**CITY OF PORTLAND, MAINE
DEVELOPMENT REVIEW APPLICATION
PLANNING DEPARTMENT PROCESSING FORM**

2003-0068
Application I. D. Number
3/31/2003
Application Date

Lot #13, Presumpscot River Place 3
Project Name/Description

13 - 13 Hope Ave, Portland, Maine
Address of Proposed Site
389 G003001 → will be 392-A-013
Assessor's Reference: Chart-Block-Lot

Drawing Name: **Lot 13 Grading & Drainage Plan**
 Project: **PRESUMPCOT RIVER PLACE**

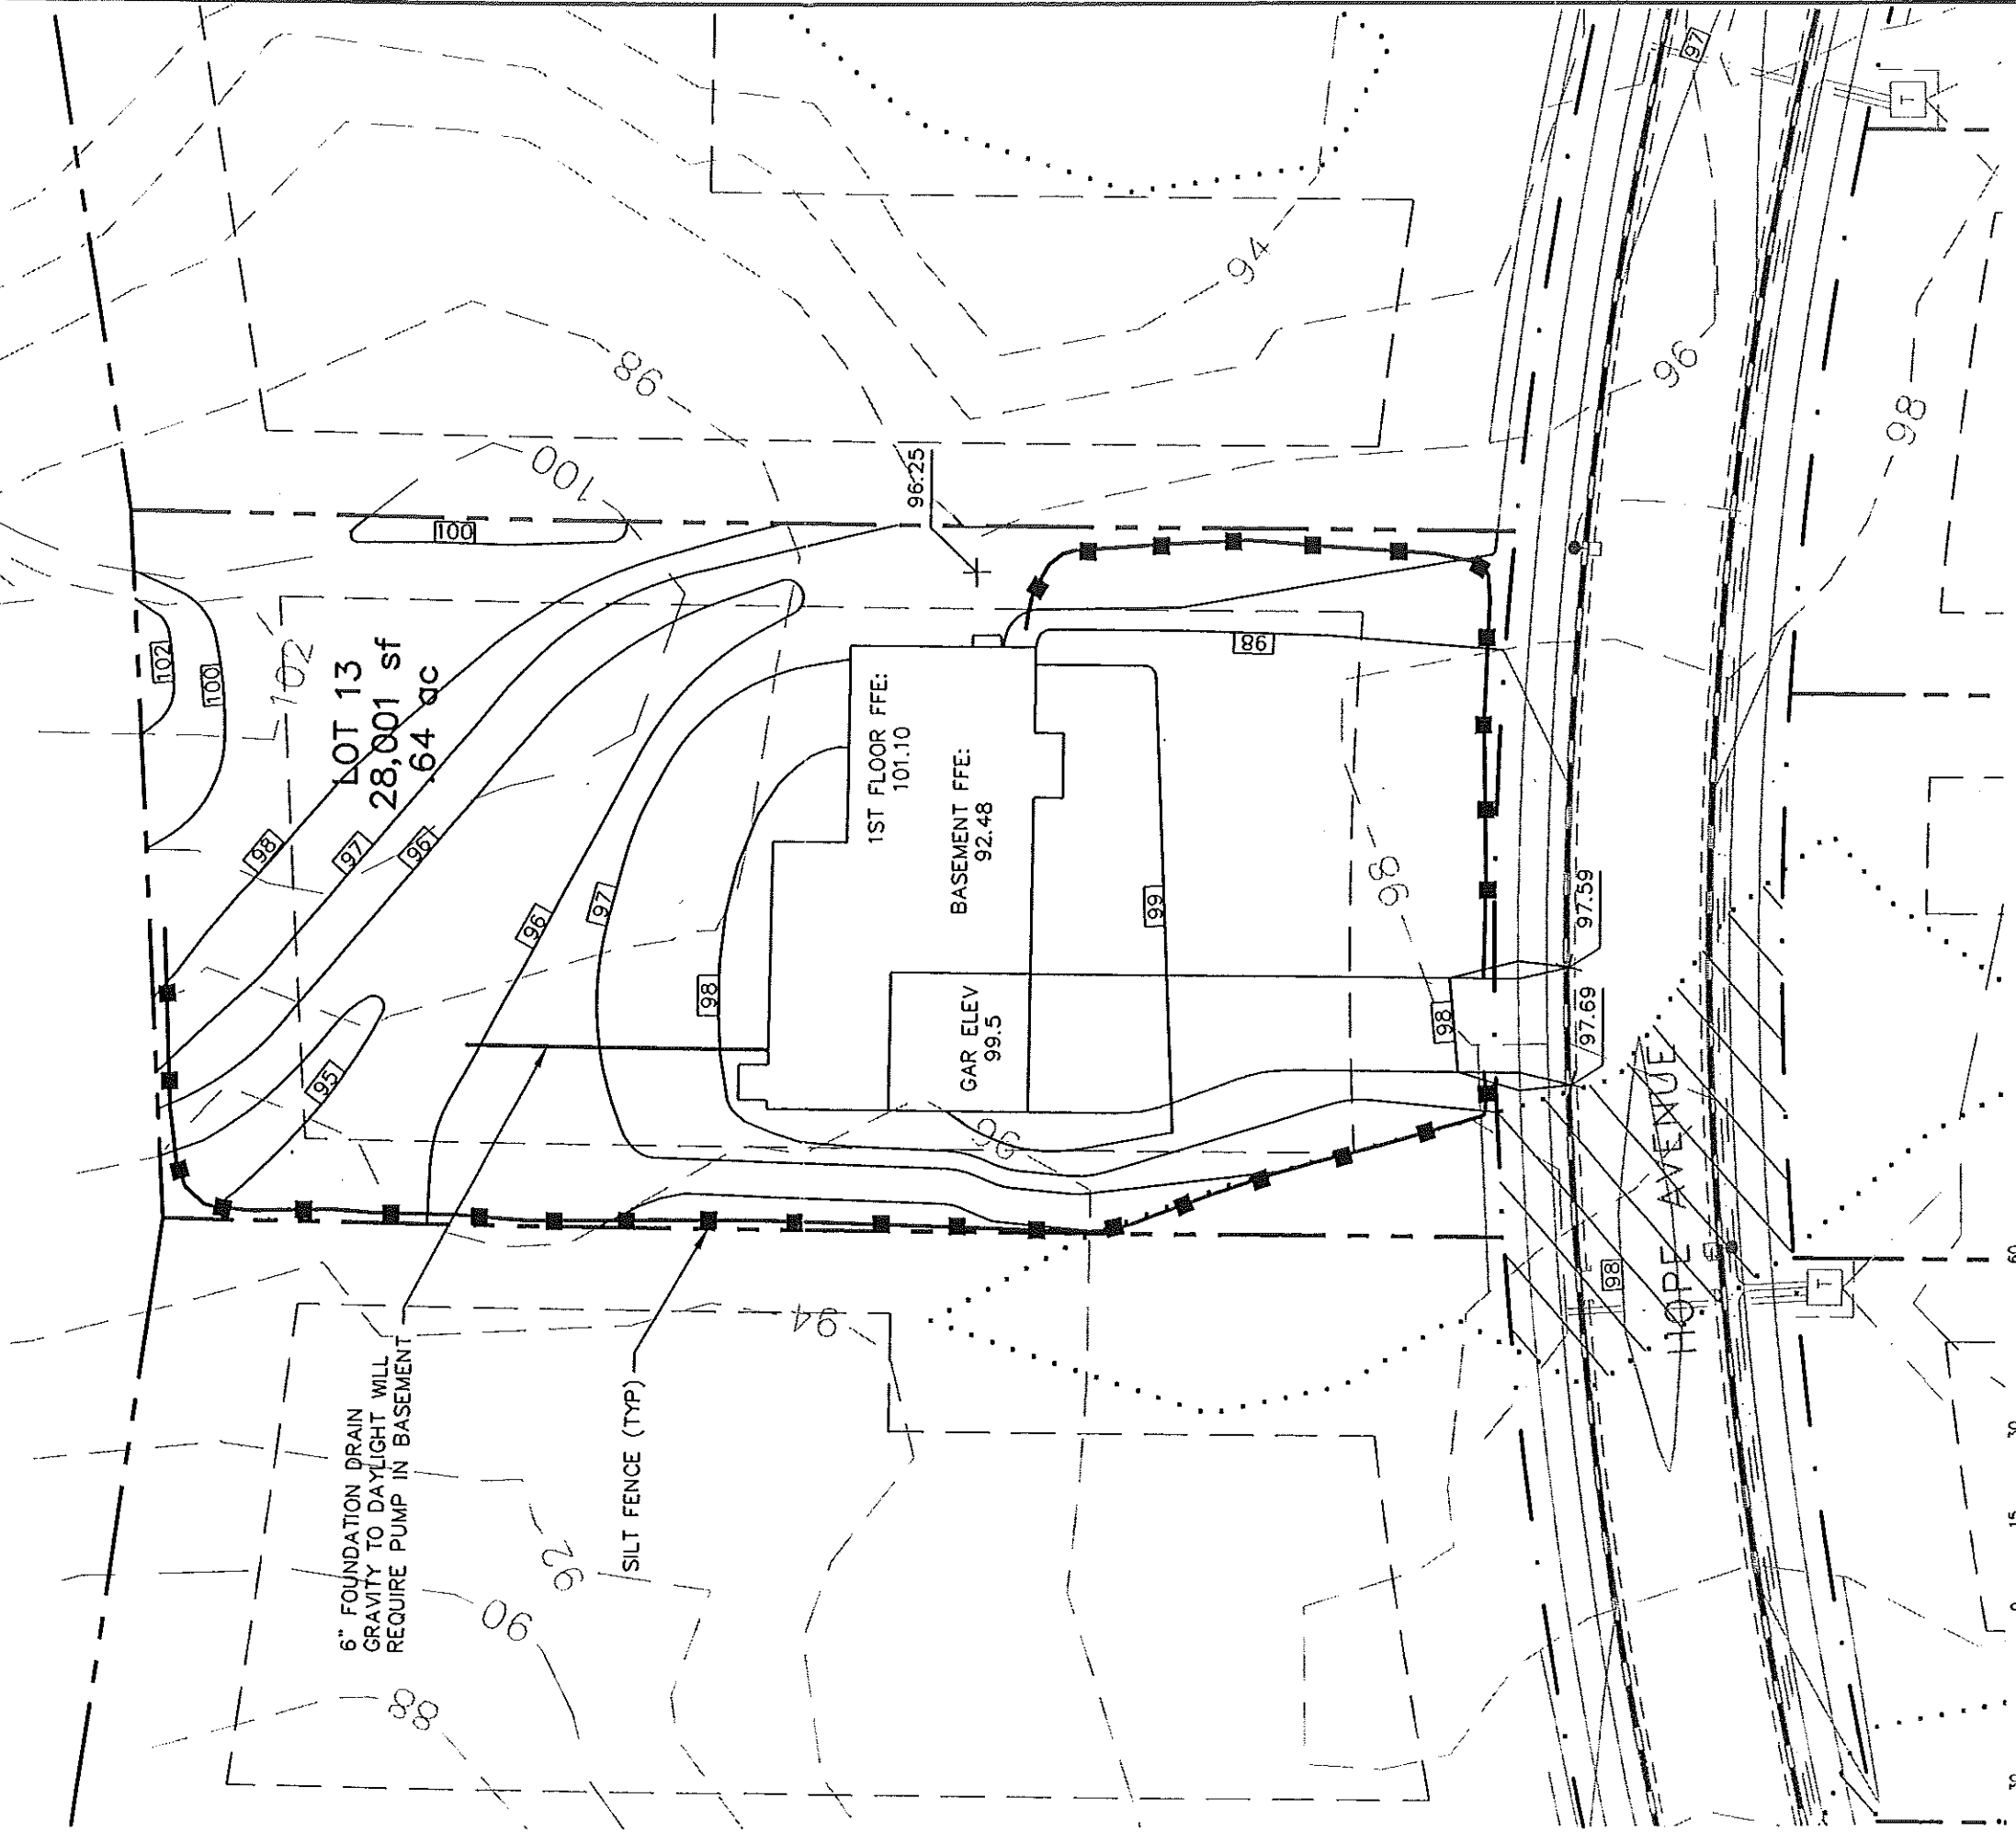
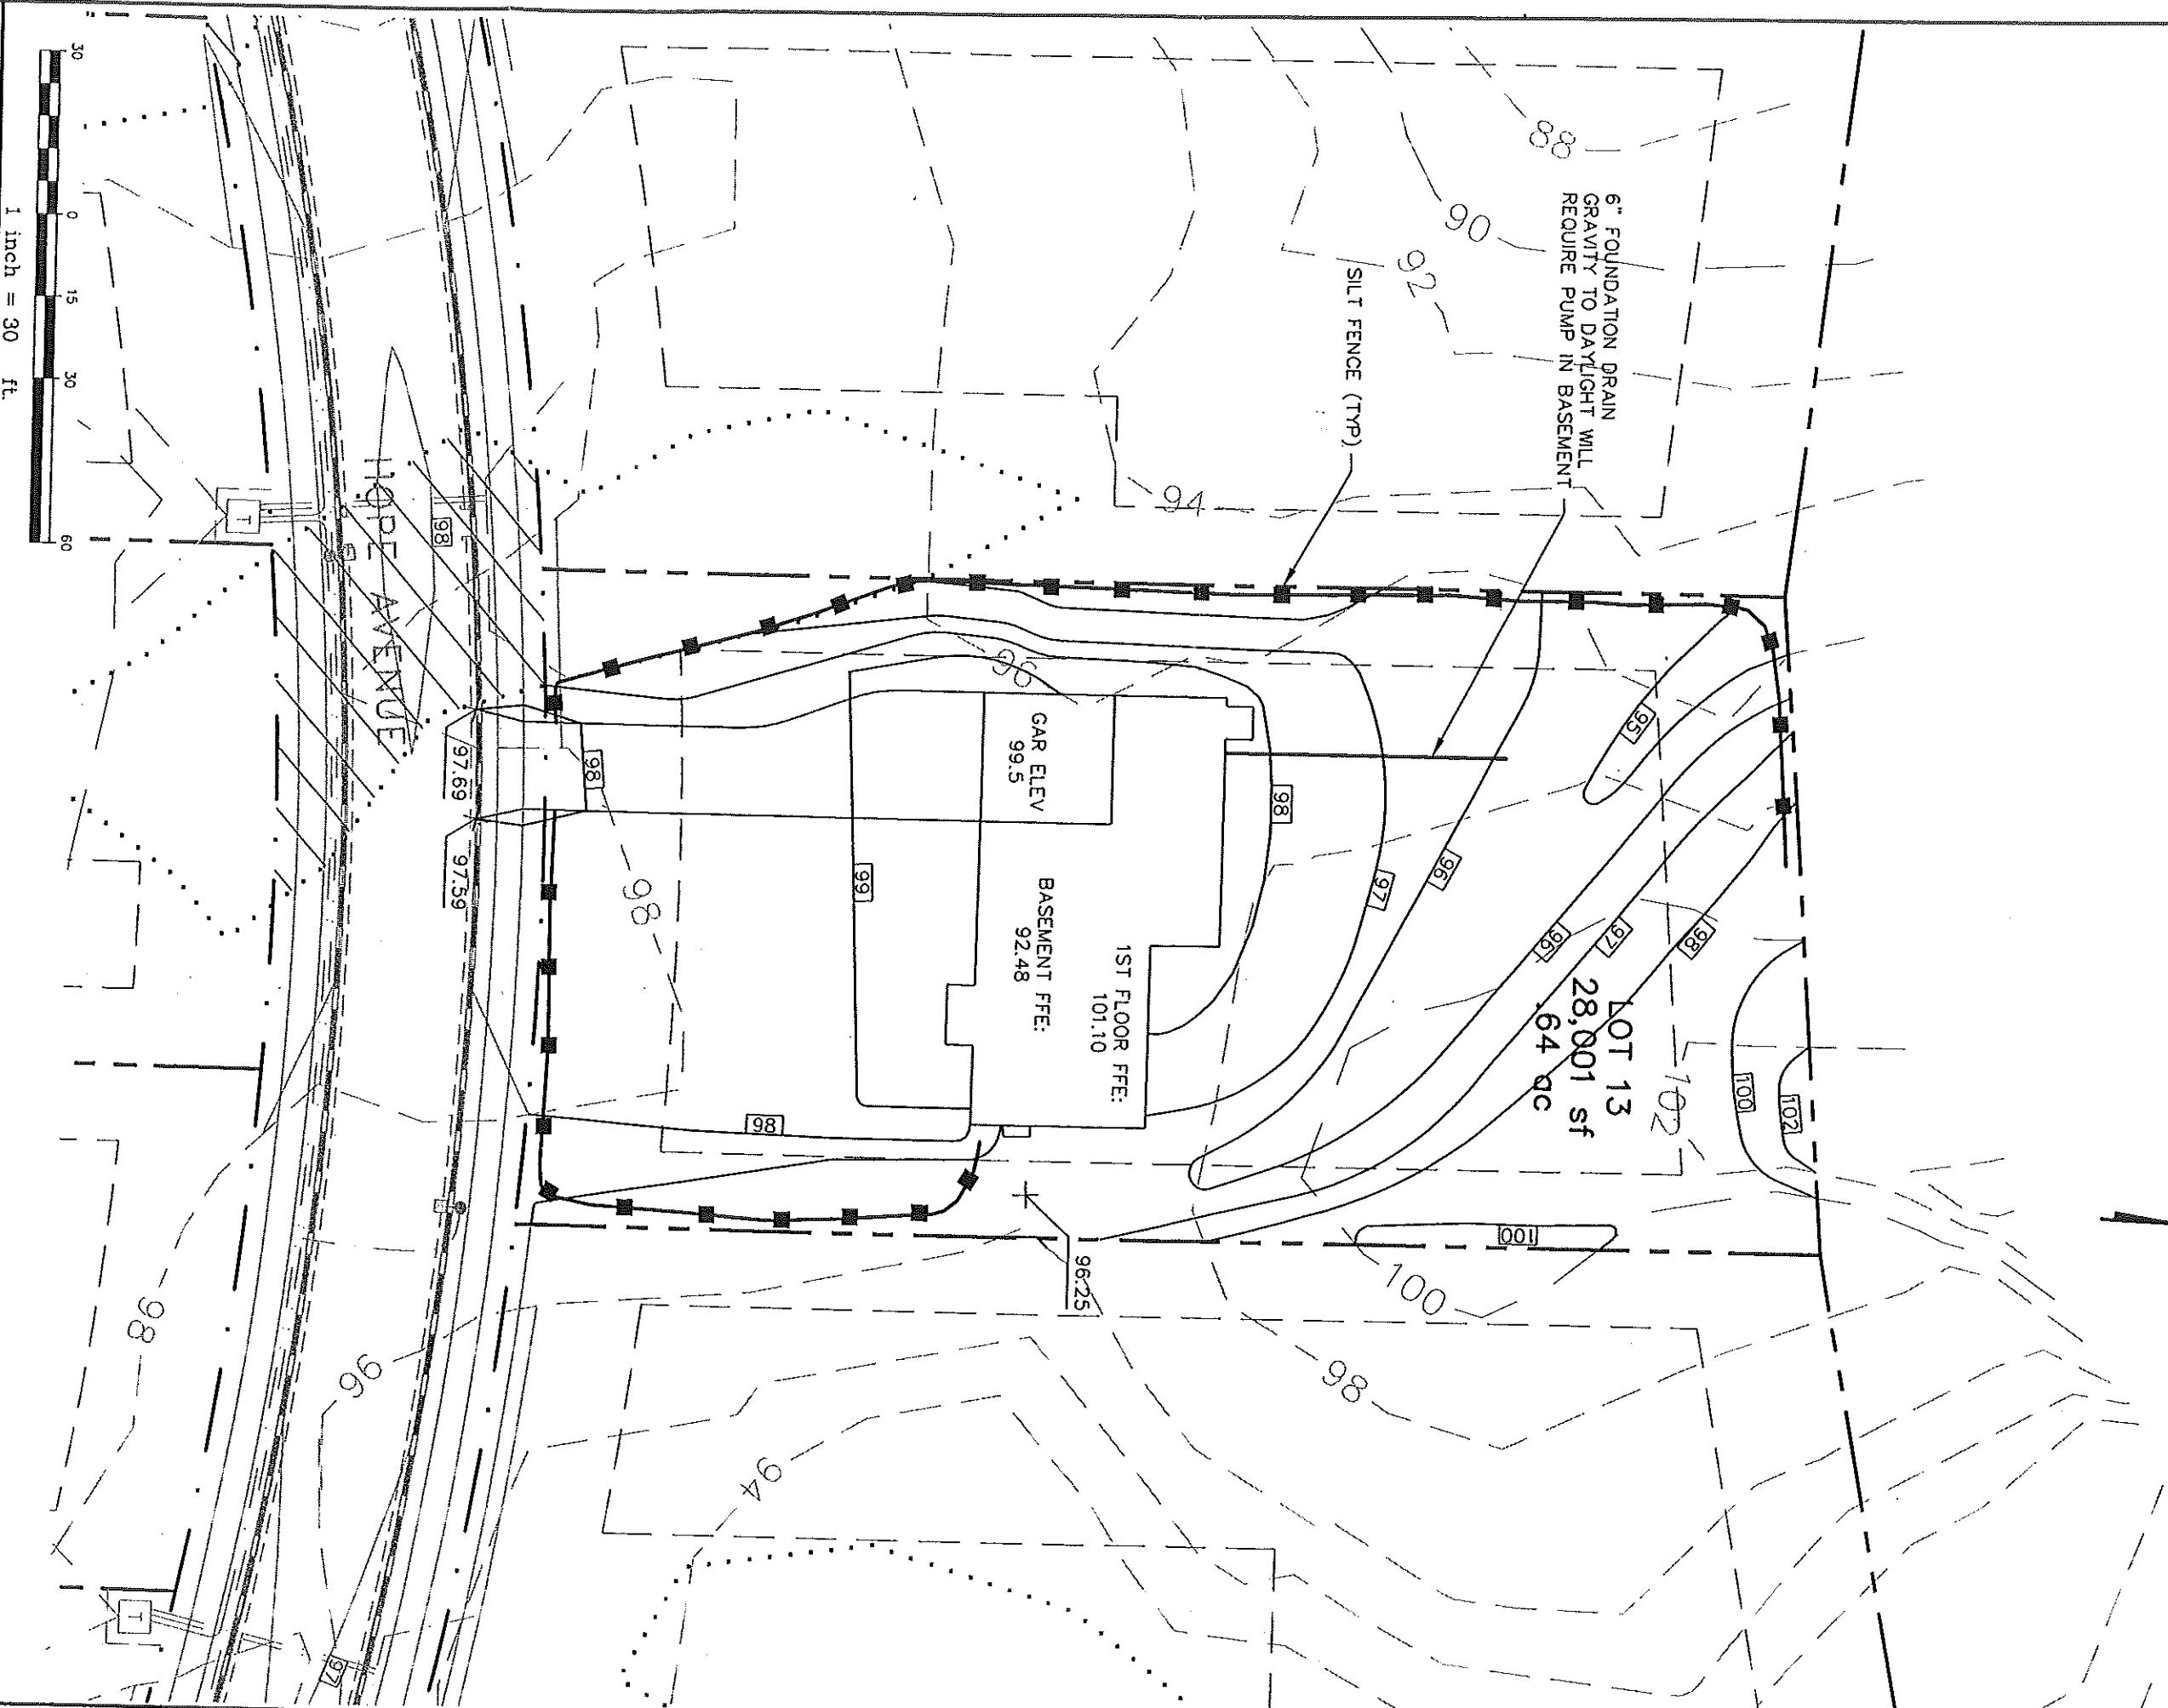
(Still on Sec. 10 97.0)
 1 Lower FFE + Grading
 2 Wetlands on lots limited to fill??
 3 No Buffer No Pump System, No essments, No Pumps!

Called Doug R. GRS - Required Revisions
